**WEST SUSSEX COUNTY COUNCIL
INFRASTRUCTURE CONSULTATION**

SUBJECT: LU/3/11- Minor amendments to LU/44/10 (WSCC NOT consulted?). Rear extension, garden store, new entrance drive and crossover.

Berry House, Berry Lane, Littlehampton, West Sussex, BN17 5HD

Block plan

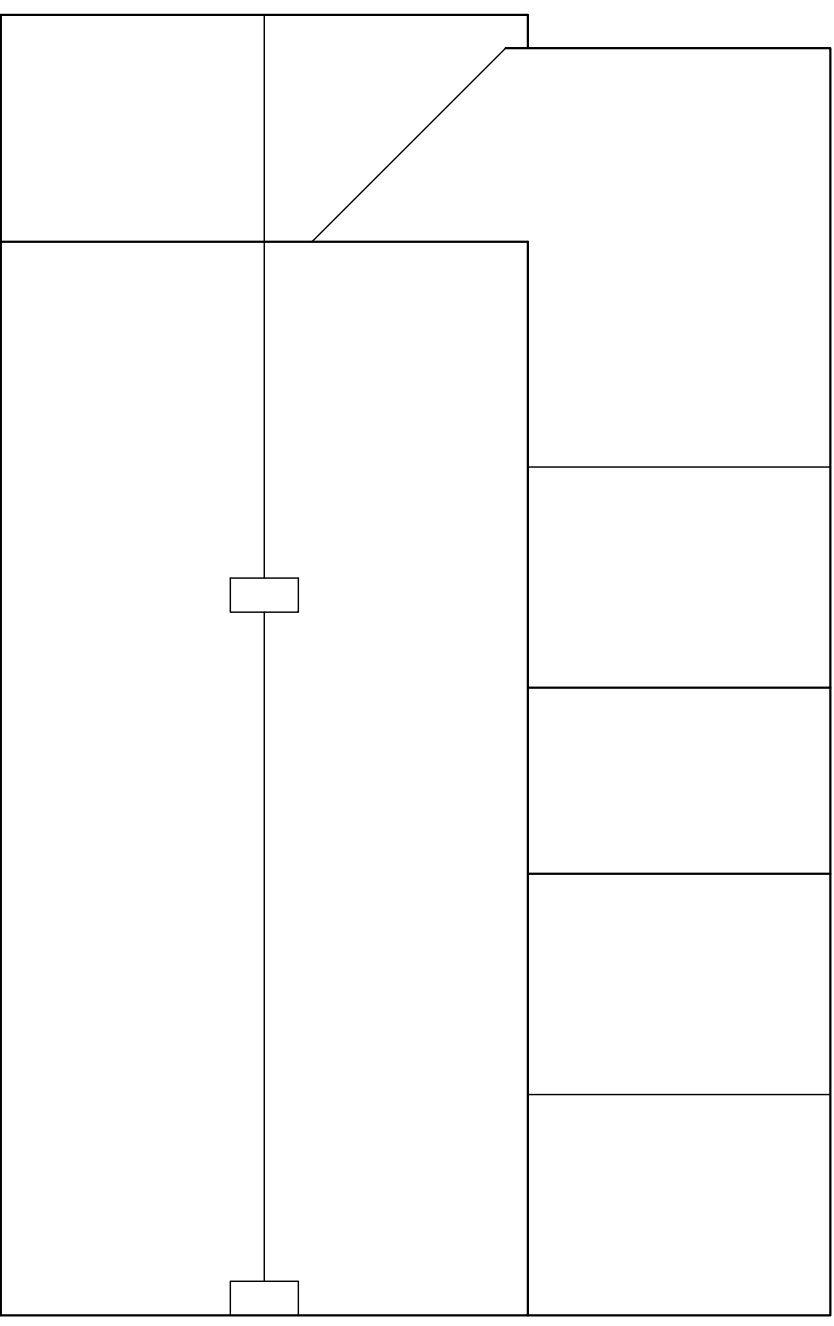
From an inspection of the supporting plans it appears the property is proposing an "in and out" access arrangement. This arrangement is unlikely to obtain a licence from the area engineer. In urban areas it is our policy to now limit access to one per property. This is because each access takes away a parking space and in most cases, the distance between the two accesses is too small to allow parking between them. Therefore the whole property frontage would be devoid of on-street spaces. If other residents along Berry Lane followed lots of on-street parking would be lost. An "in and out" access is an inefficient way of providing car spaces on a forecourt. There is sometimes a reluctance to park more than one car on such an arrangement as one car may block the other. If more than one car uses this arrangement, there is no benefit since they can't drive "in and out" without reversing. Often more cars can be accommodated with one wide access widened to a maximum of 6.3 metres.
